SUBJECT: **SFD2404-0118**
SINGLE FAMILY DWELLING

Here are the results of all Inspections located at **14652 MCDOUGALD RD:**

**S0.2**

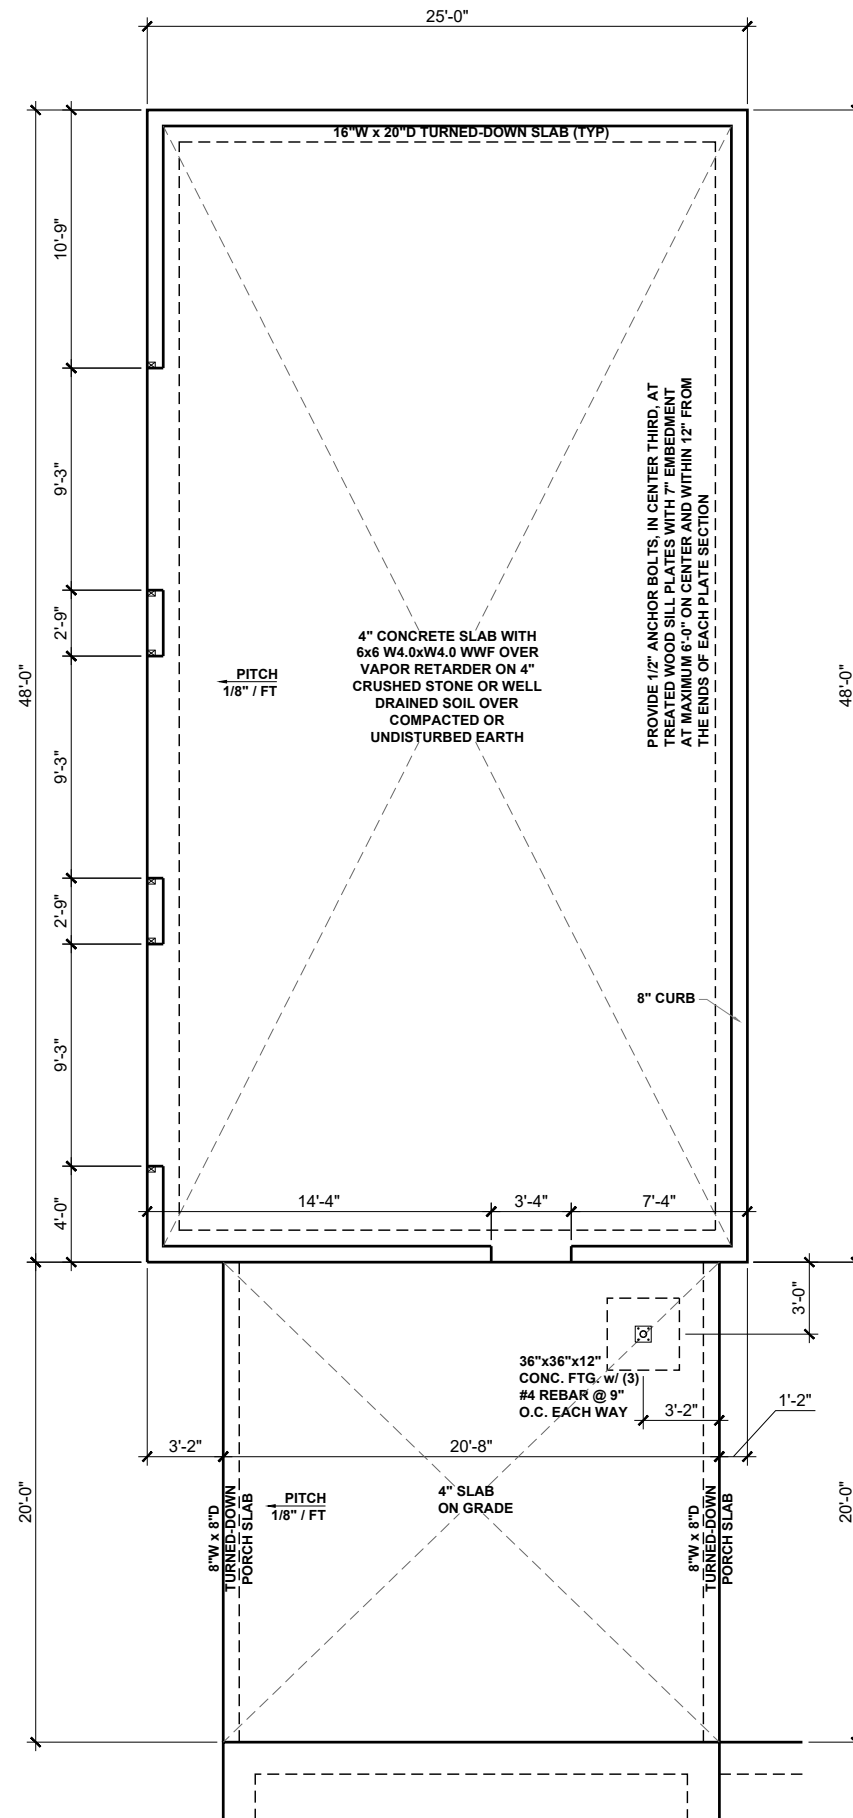
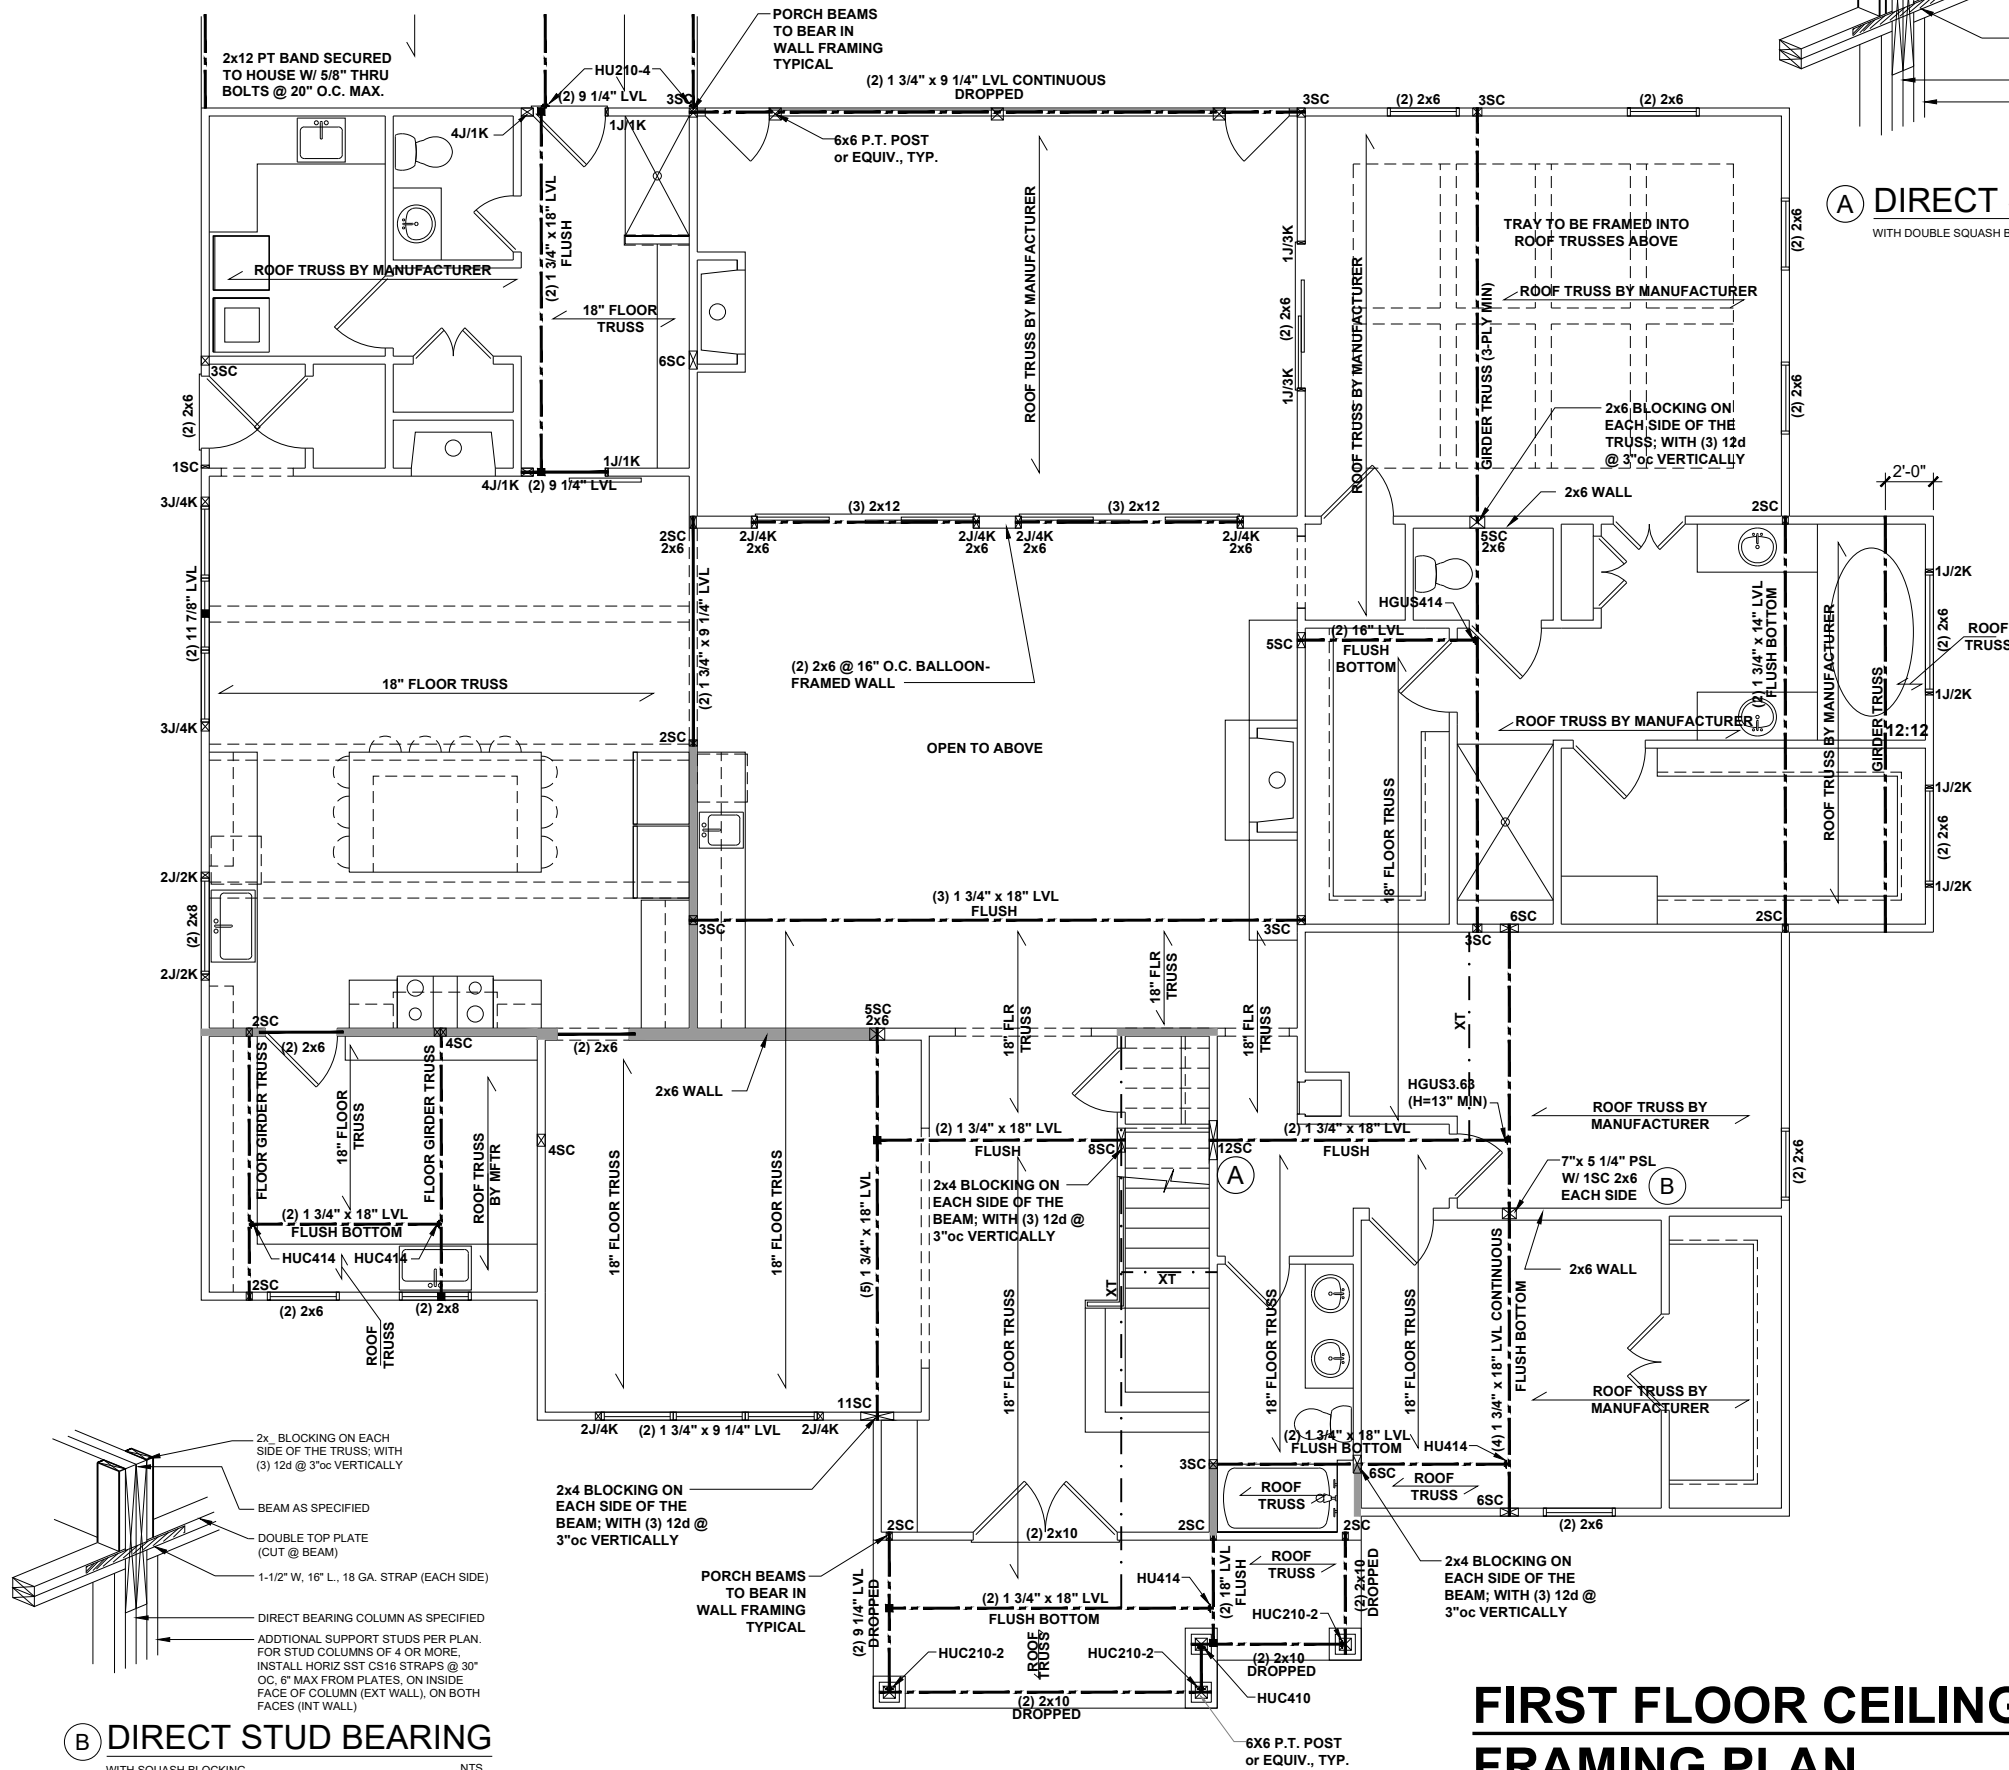
Inspection Type: MONO SLAB
Scheduled Date/Time: 10/10/2024
Completed Date/Time: 10/10/2024
Inspector: John B Kokoszka
Result: DISAPPROVED
Remarks:
Notes: Still working on mono. Going to need compaction test for garage. Still missing wire mess. From porch needs to be 16x20 Back porch needs wet soil. Middle 6.5 ft lug footing was crooked, needs to be straightened out

Inspection Type: ROUGH IN REINSPECT
Scheduled Date/Time: 11/21/2024
Completed Date/Time: 11/21/2024
Inspector: John B Kokoszka
Result: DISAPPROVED
Remarks:
Notes: Need to have compaction test and third-party mono. Detest Garage is supposed to be attached, but hasn't been attached yet. Didn't do the rough thing.
